KINGSCLIFF RATEPAYERS and PROGRESS ASSOC. inc
PO Box 1164, Kingscliff NSW 2487

Date: 21st February 2014

Re: Kings Forest – MP 06_0318 MOD4 & MP 08_194 MOD 2

Figure 2 Kings Forest Precinct Plan (Source: Planit)

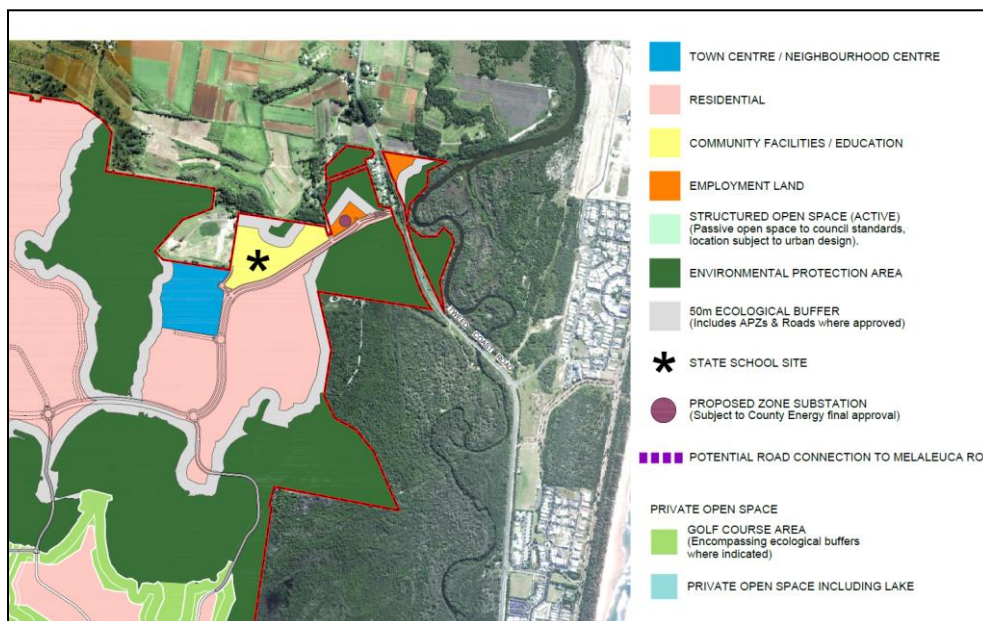
*In the PRECINCT PLAN the affordable housing, (subject to approval and financing) and shown as a red triangle, is too far away from the shopping centre and the school. The residents of “affordable housing” are often pensioners, single parents or on a disability pension.

The distance that these residents may need to travel to the shopping centre is more than seven hundred metres (700m along the footpaths) and many of the affordable housing residents may not have cars / transport.

We believe that a better place for these residents would be in precinct 4.
